CITY OF PORTLAND, MAINE
DEVELOPMENT REVIEW APPLICATION
PLANNING DEPARTMENT PROCESSING FORM

Carriage Lane Duplex

Lot #2

RE: Applications for Carriage Lane Duplexes, Lots 1 and 2

Drawing Name: **Lot 2 Lot Layout and Utility Plan**
 Project: **CARRIAGE LANE**

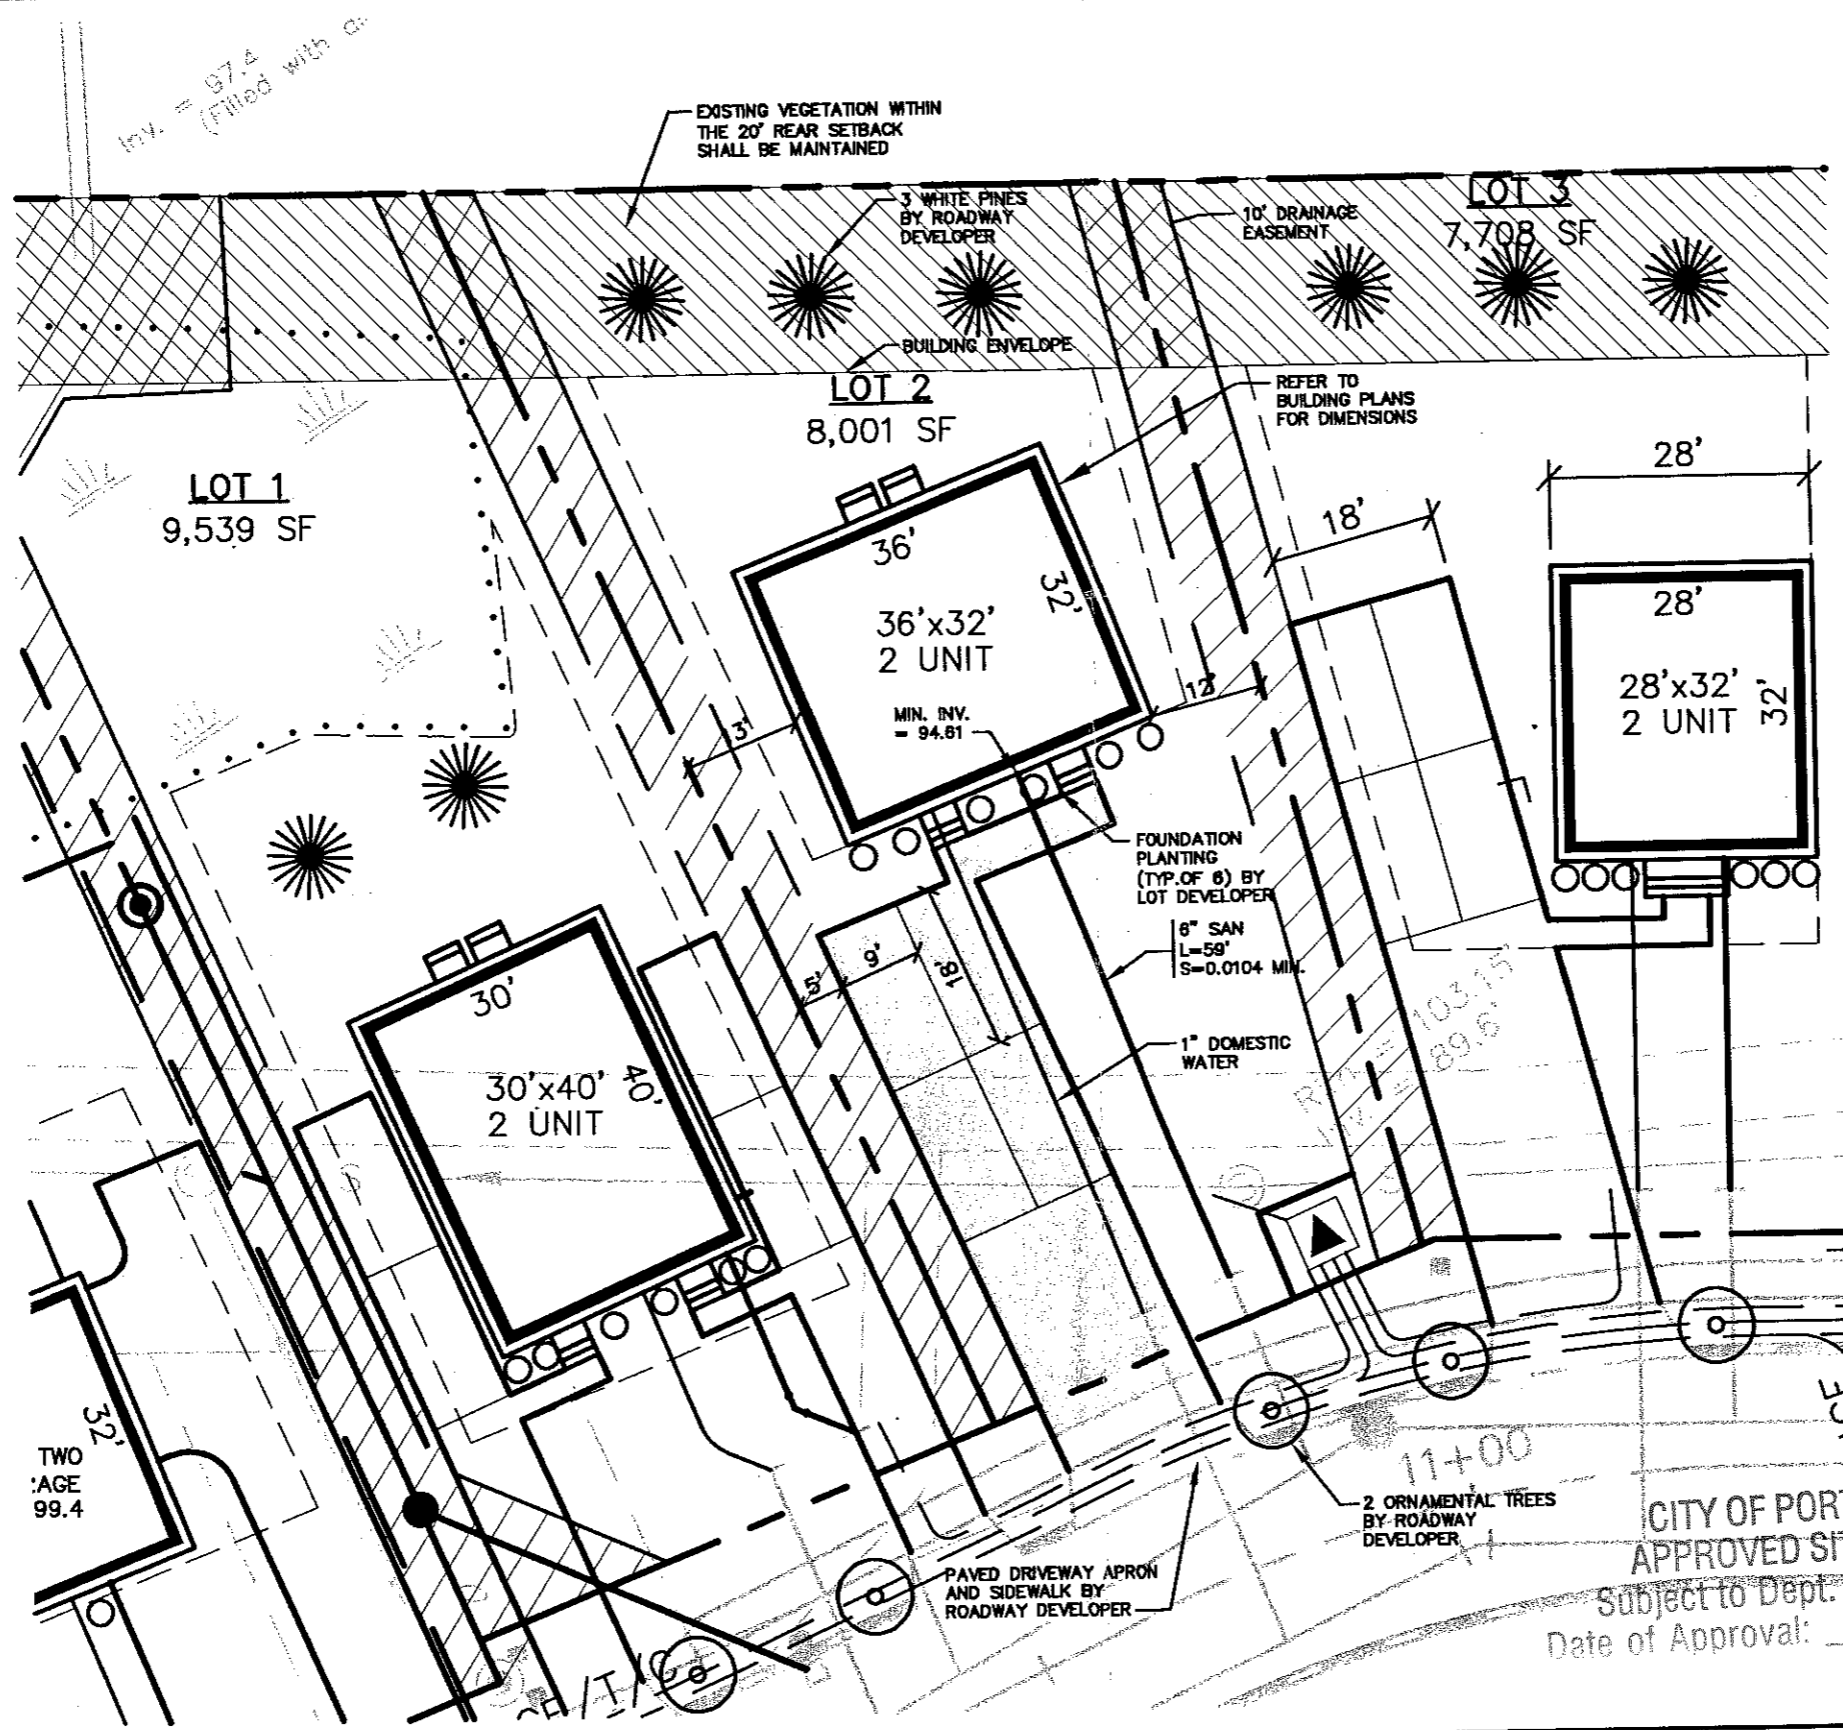
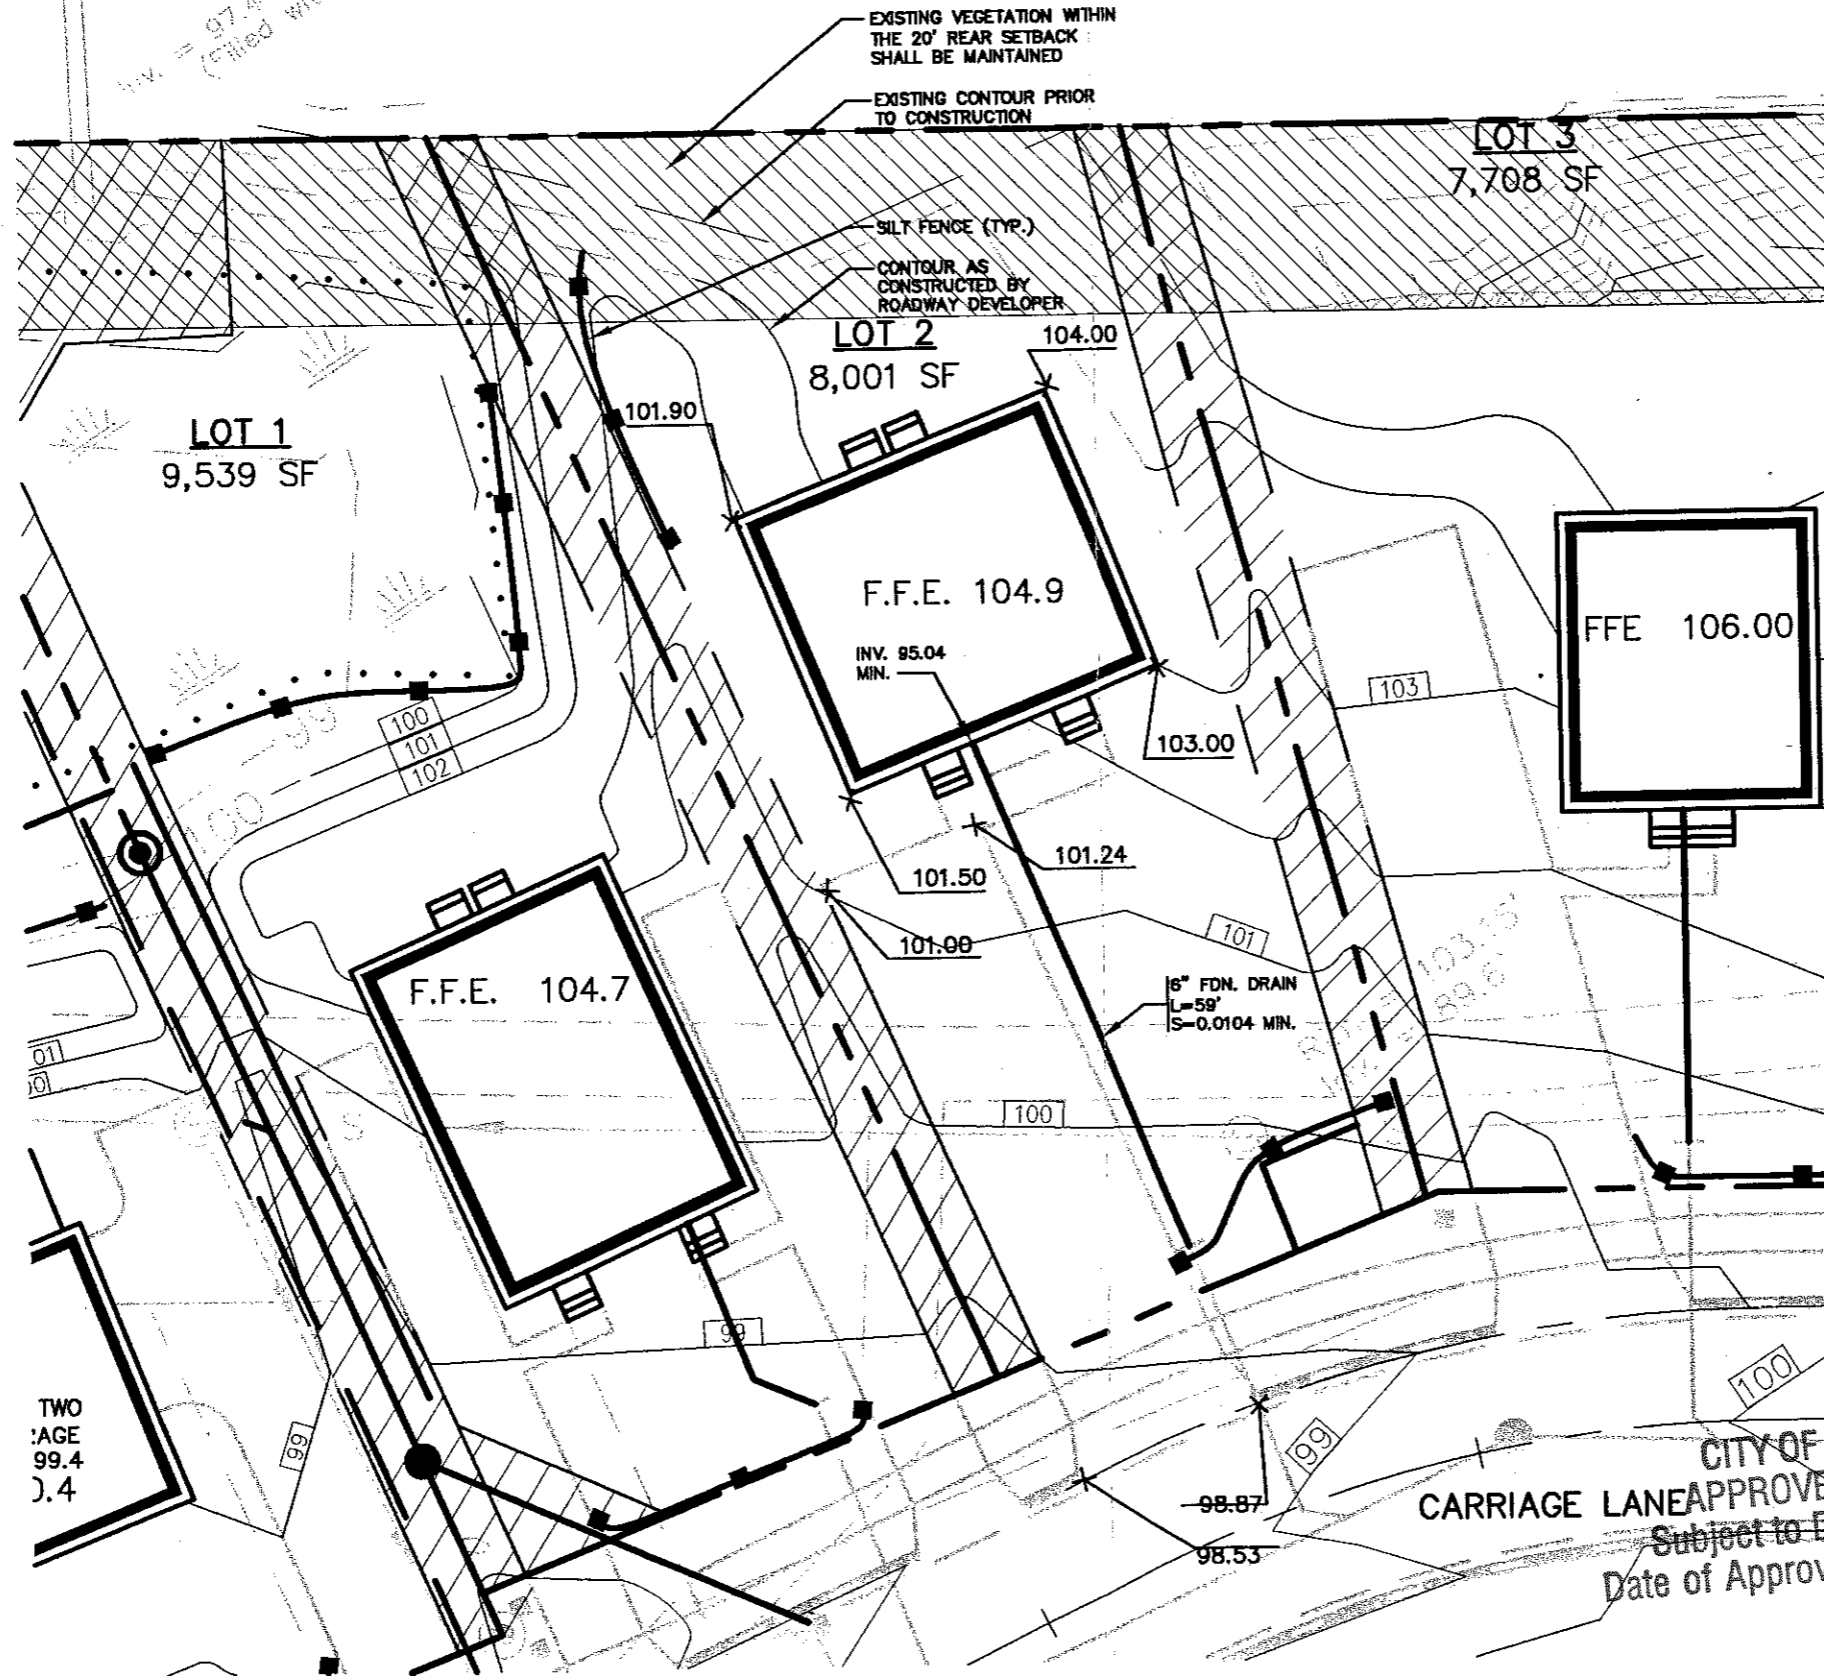
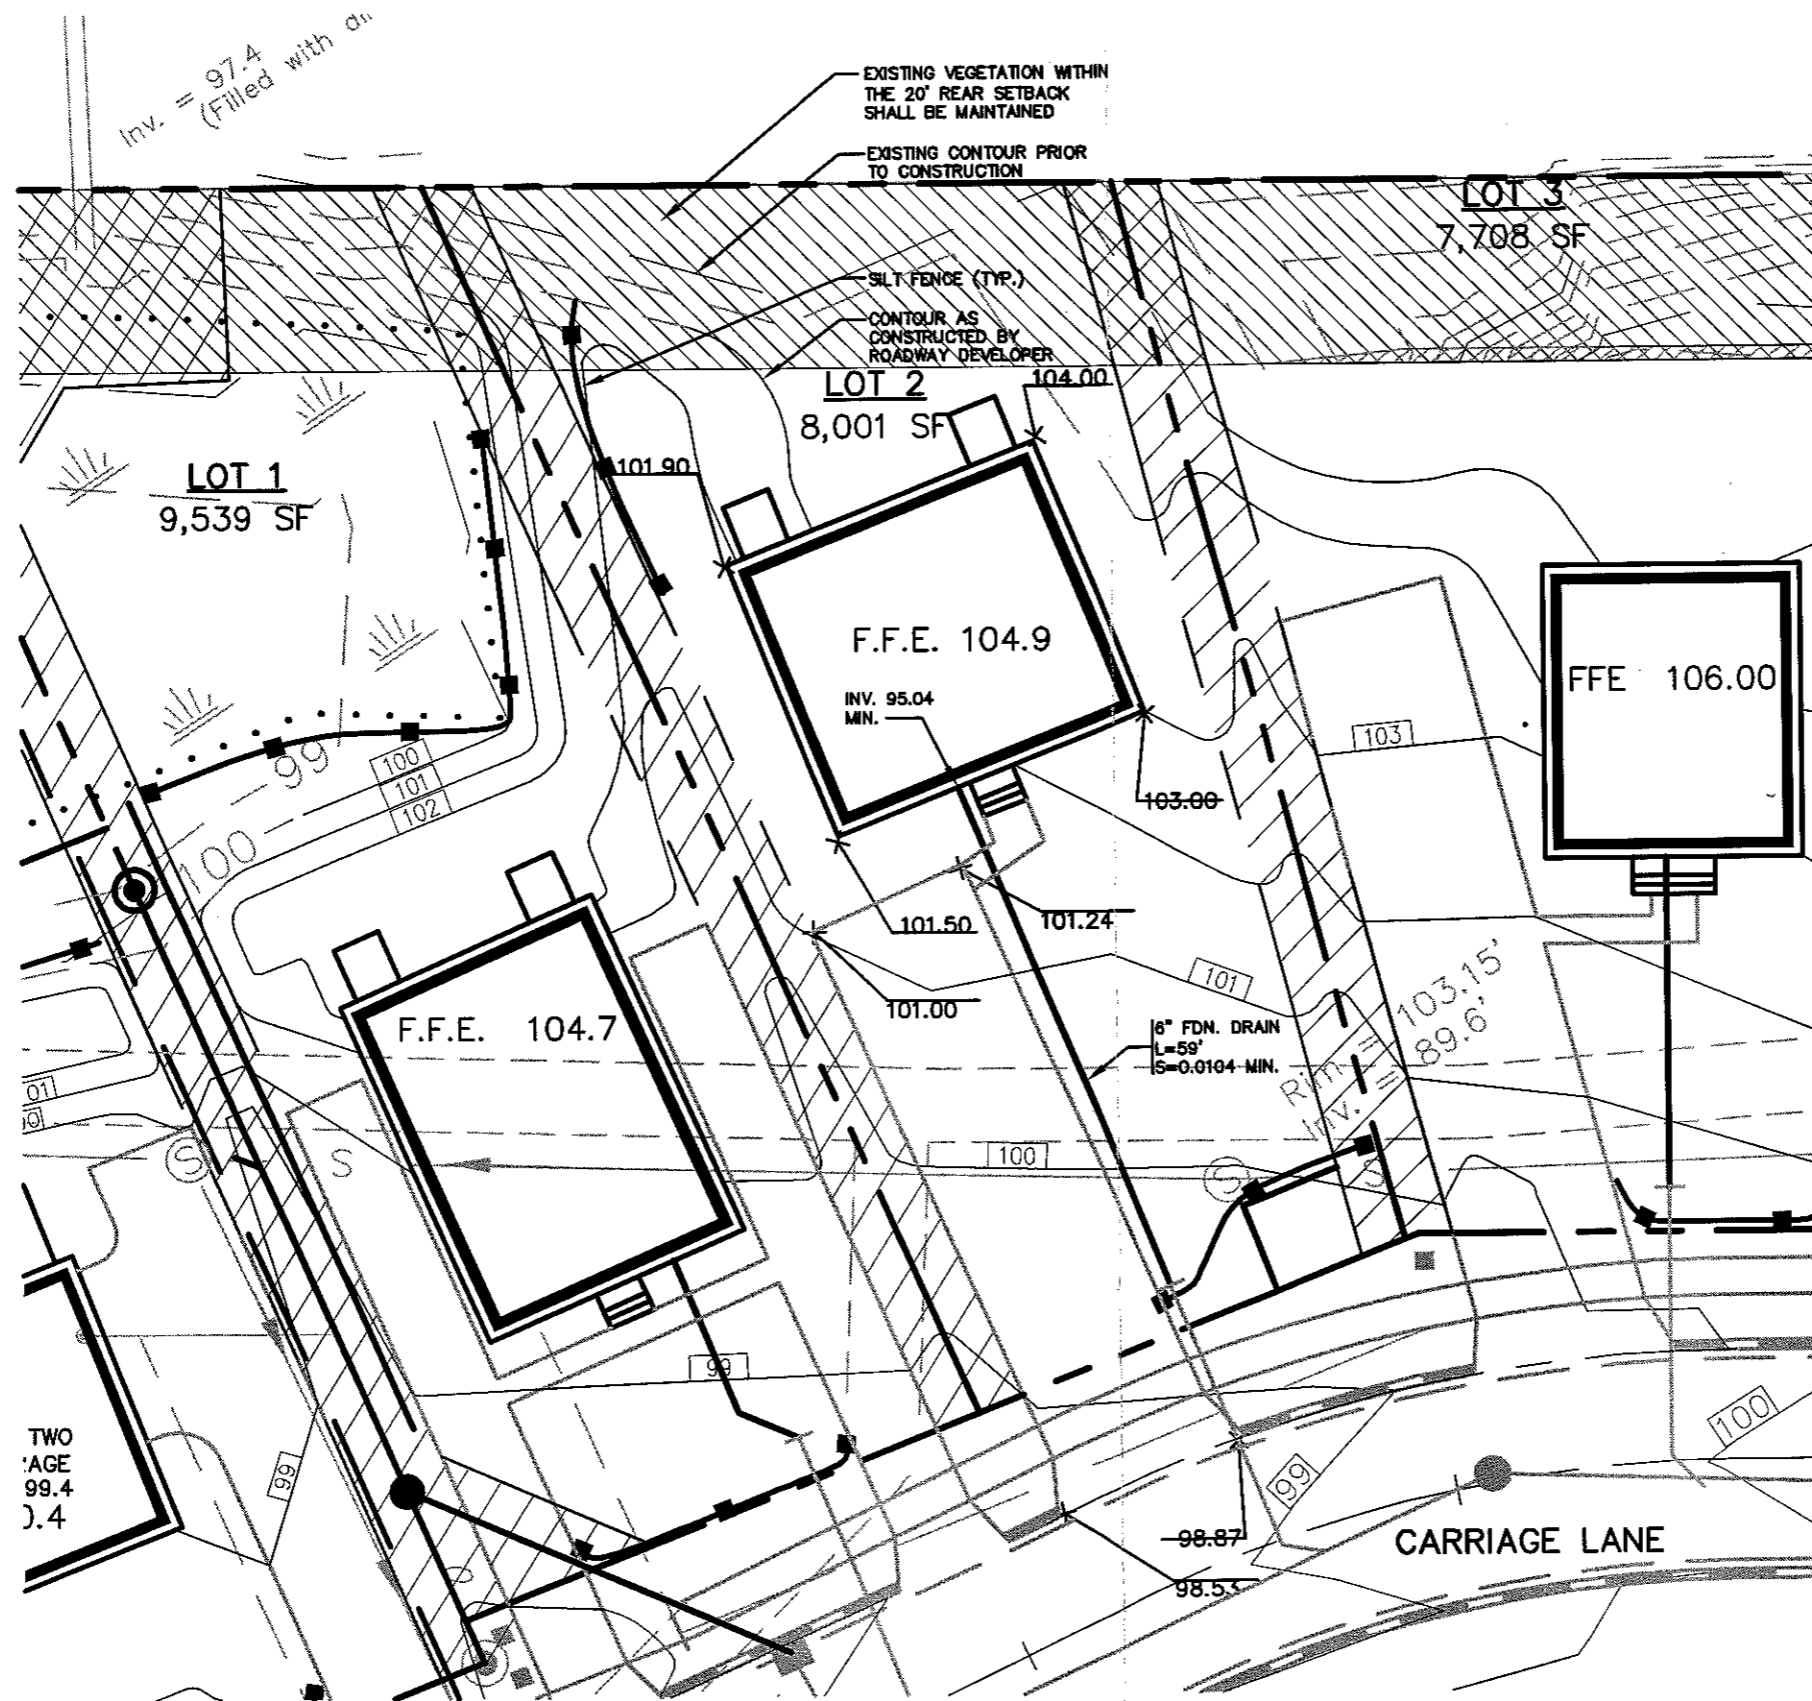
1. Lot #1:
 - a. The proposed easement shown in the front/left portion of the lot has not been finalized by the developer. An amended subdivision plat is needed for the Planning Director's signature, then it needs to be recorded at the registry of deeds. Also, a mylar and 7 paper copies of the recorded version then must be delivered to the City.
 - b. The porch/stairs and the site plan do not match.
 - c. The scaling appears to be off.
2. Lot #2:
 - a. There are a number of lines on sheet #1 that have no meaning. Please label or remove them.
 - b. The porch/stairs and the site plan do not match.
 - c. The scaling appears to be off.
